TIERRA WEST, LLC

**RE: LOT 22 MERIDIAN BUSINESS PARK
541 SILVER CREEK RD NW
TRAFFIC CIRCULATION LAYOUT
ENGINEER'S STAMP 07-09-2020 (K10-D023I)**

Per the TCL comments dated 07/15/2020 for LOT 22 MERIDIAN BUSINESS PARK, please find the following responses addressing your comments listed below:

AUTOTURN EXHIBIT (WB-65)
7-14-2020

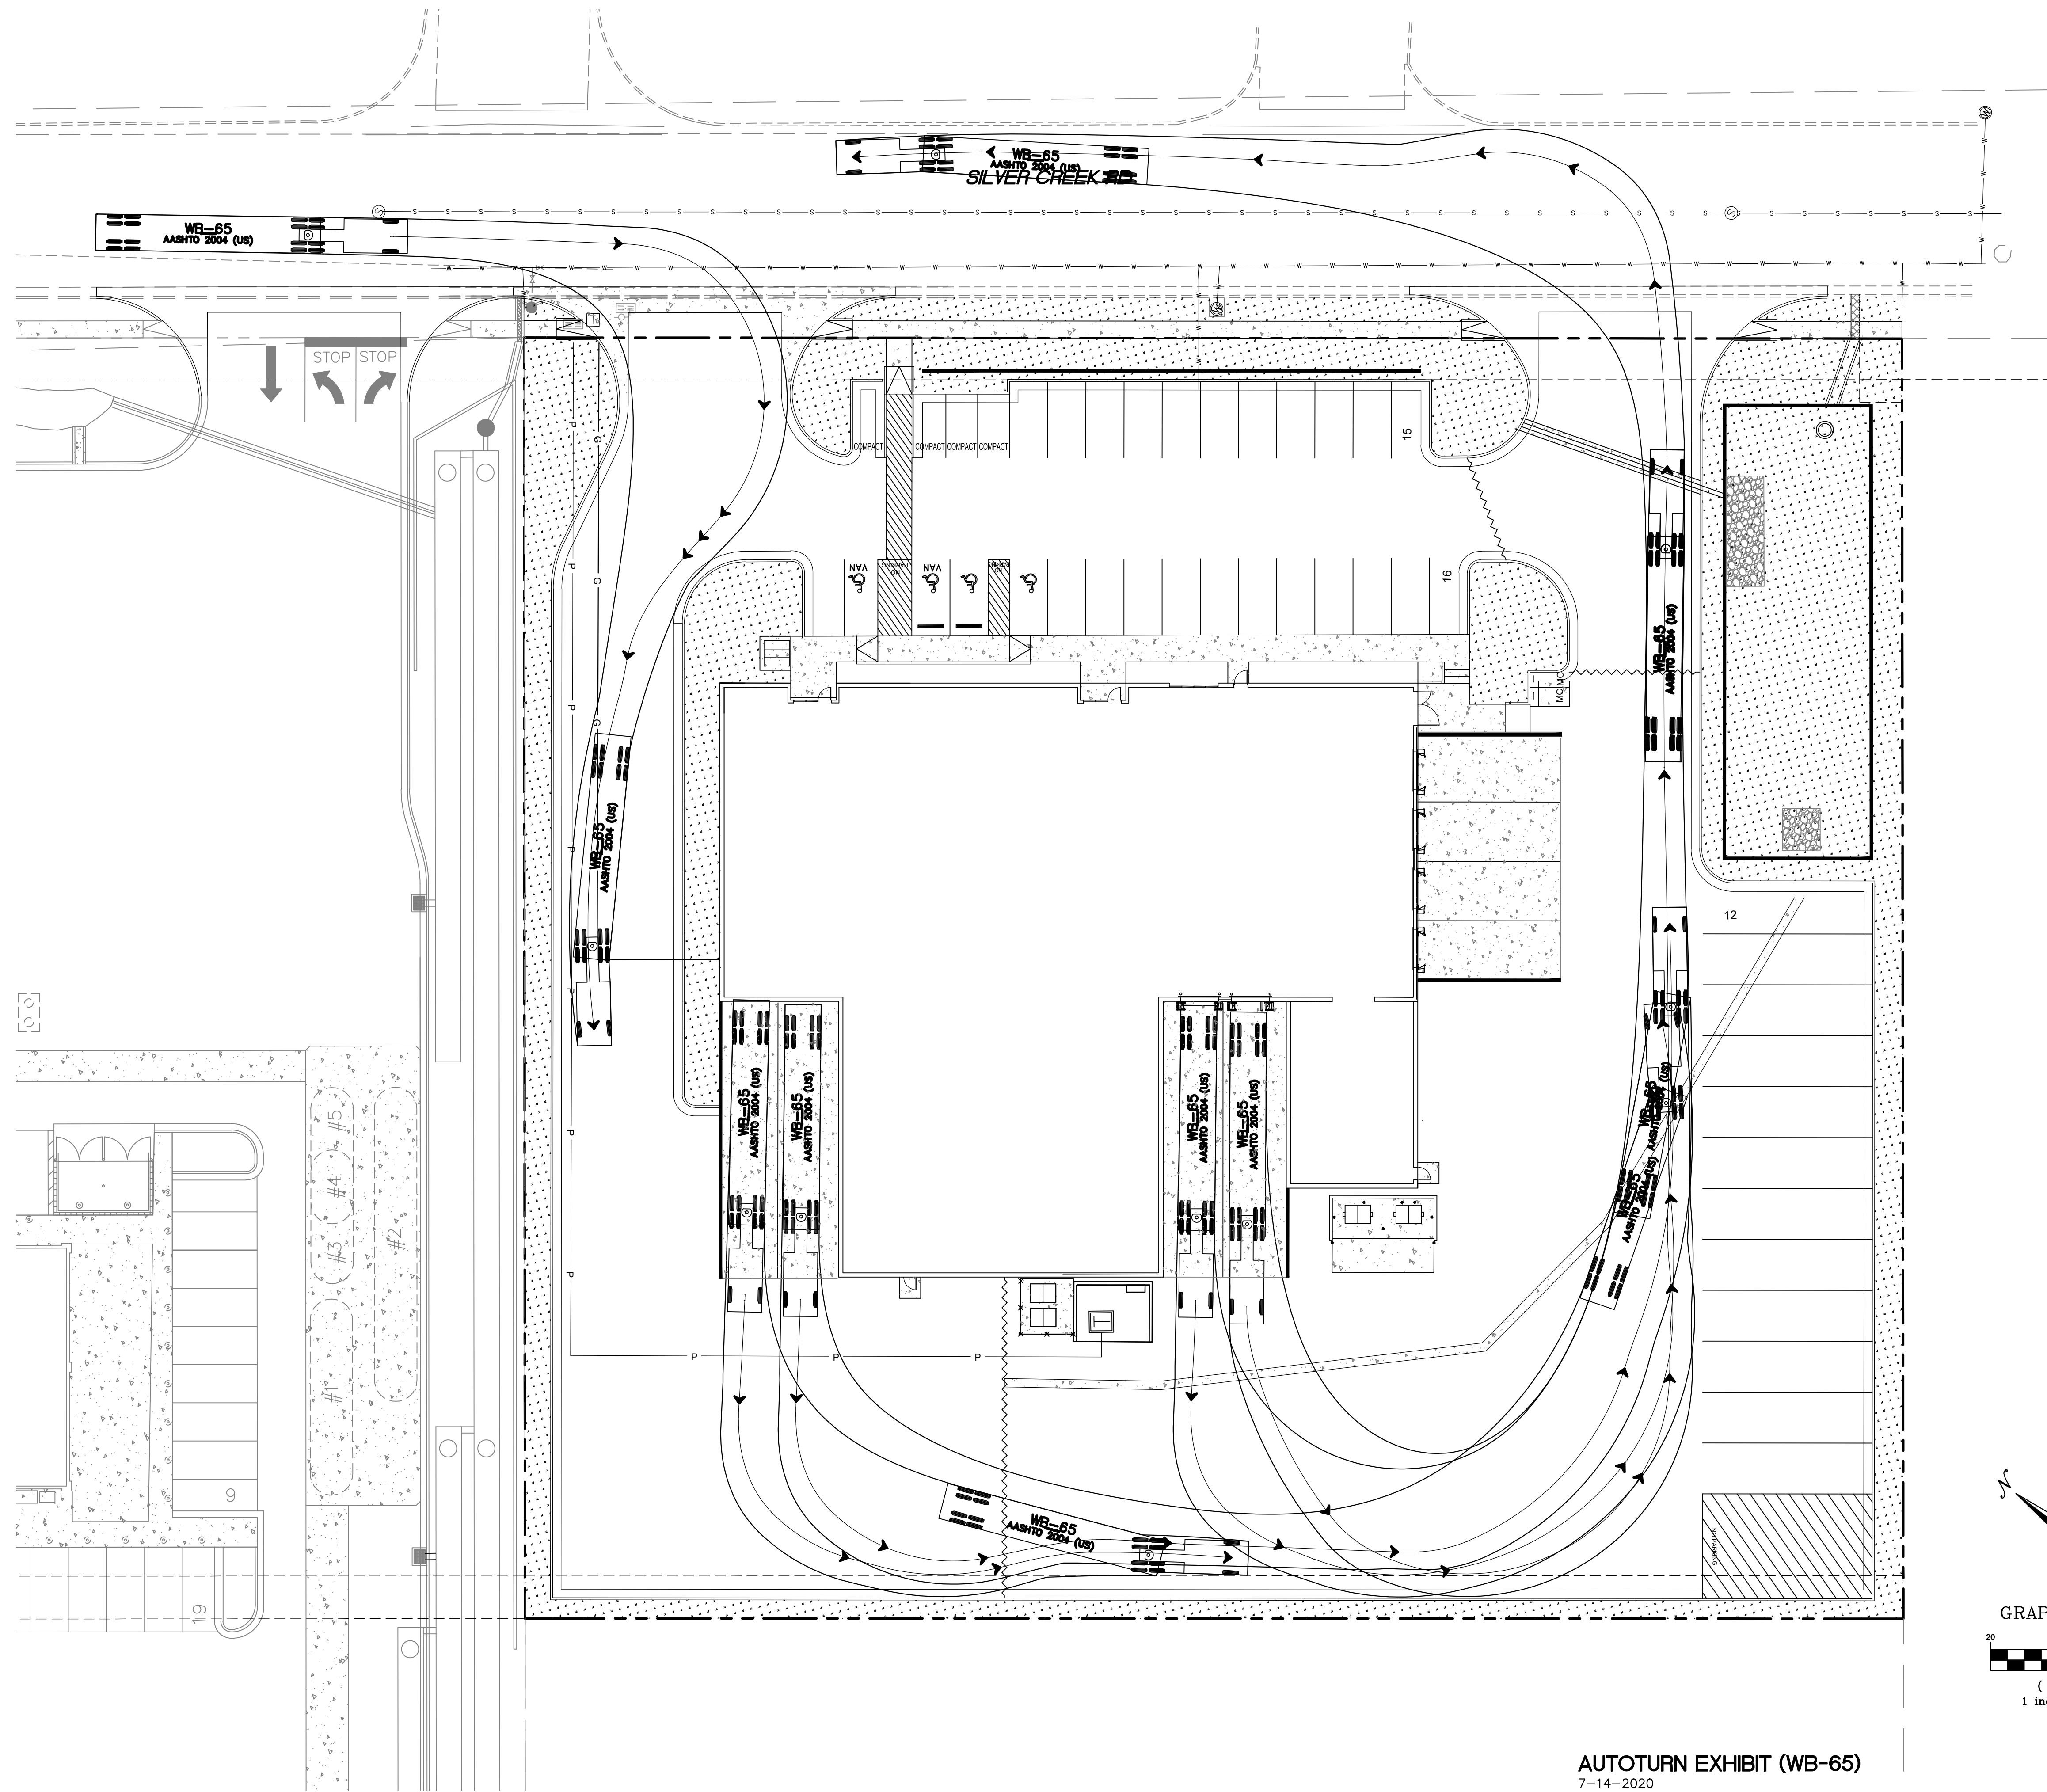
2. Please provide turning templates for delivery vehicle from public roadway into and out of site back onto Silver Creek Road. Need to show how WB 65 maneuvers out of the site onto Public Street without encroaching onto opposing traffic flow.

Response: See attached Autoturn exhibit showing WB65 vehicles existing the site to Los Volcanes.
3. The proposed 6 ft. wide ADA accessible pedestrian pathway from the public sidewalk needs to be dimensioned, as well as the proposed ramp (since you reference the site plan as the designated measurement tool).

SHEET # SP-1
			JOB # 2020033

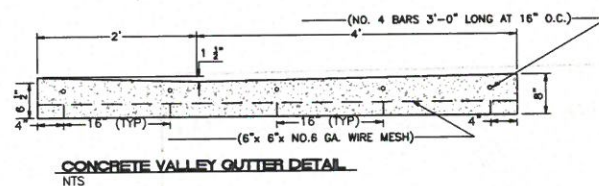
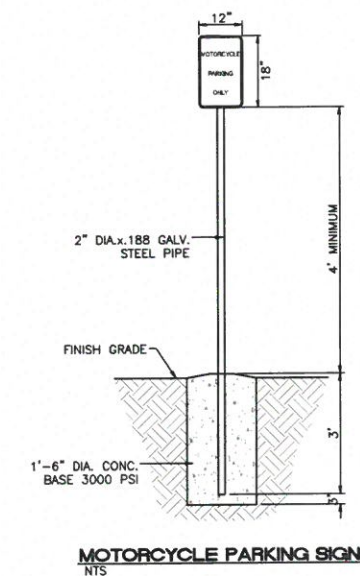
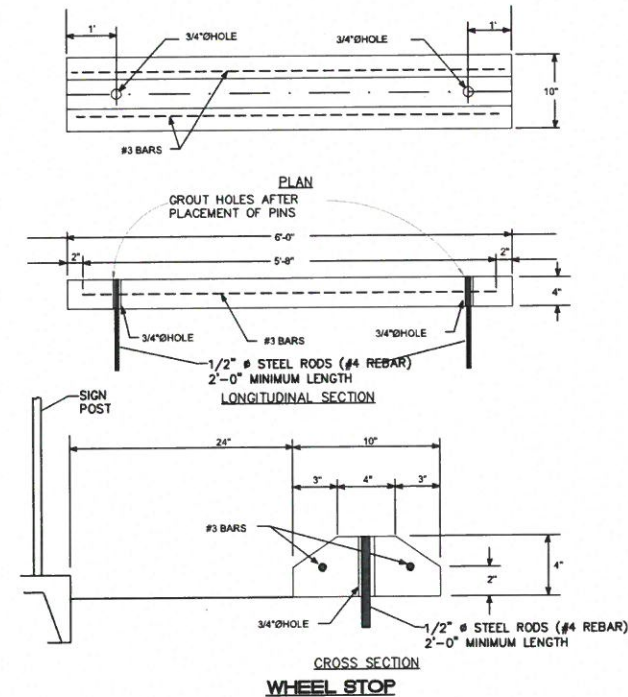
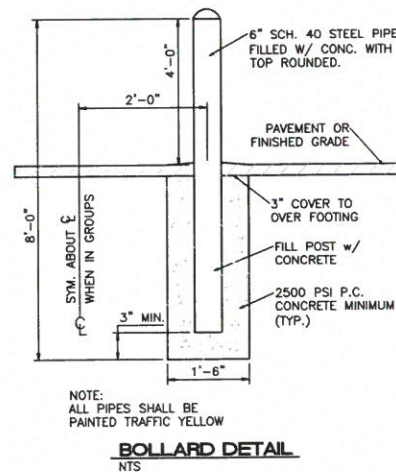
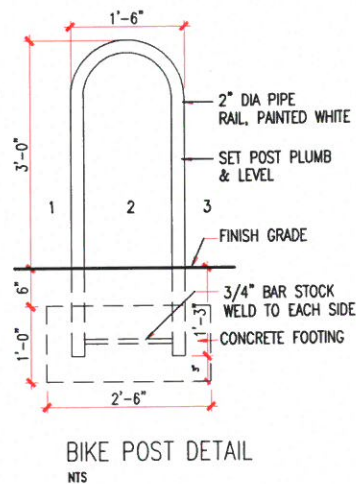
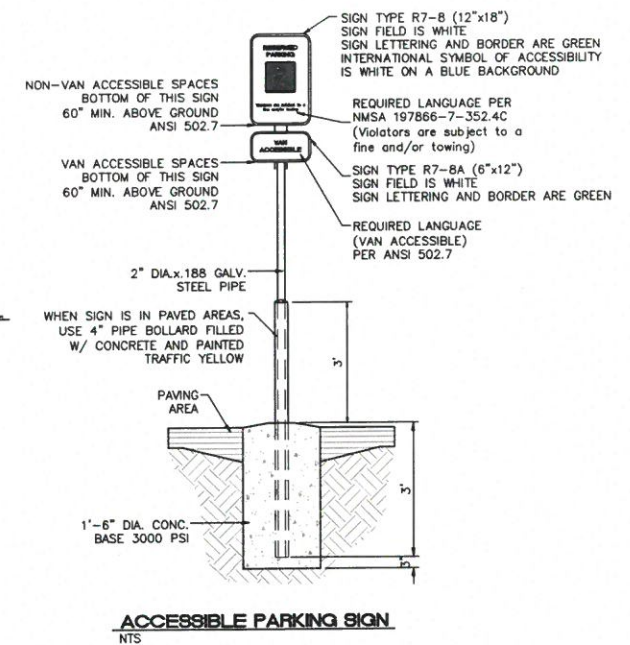
1. Please Label the compact parking spaces by placing the words "**COMPACT**" on the pavement of **each space and not the letter C.**
Response: The compact spaces have been labeled as "COMPACT"

Response: The ADA accessible pathway has been dimensioned along with the proposed ramp.
4. Parking areas shall have barriers to prevent vehicles from extending over public sidewalk, public right-of-way, or abutting lots and proposed 6 ft. pedestrian pathway in front of building entrance. You stated "A turn down curb is proposed at the front of the building. The 2' overhang will still provide a minimum pedestrian access on sidewalk". Well, the minimum for this access width is 6ft so is this what you are stating or do you need to provide parking barriers to substantiate the required minimum 6ft width???

Response: See attached site plan signed by Solid Waste Dept.
6. The proposed monument sign cannot encroached onto public right of way (**this includes air space**) Please verify that this is the condition that the sign will not encroach onto public air space.

Response: Wheel stops added to parking stalls in the front of the building to preserve the 6' sidewalk.
5. Provide a copy of refuse. This is the condition of approval prior for TCL.

Response: Noted. The sign will not encroach onto the right of way.
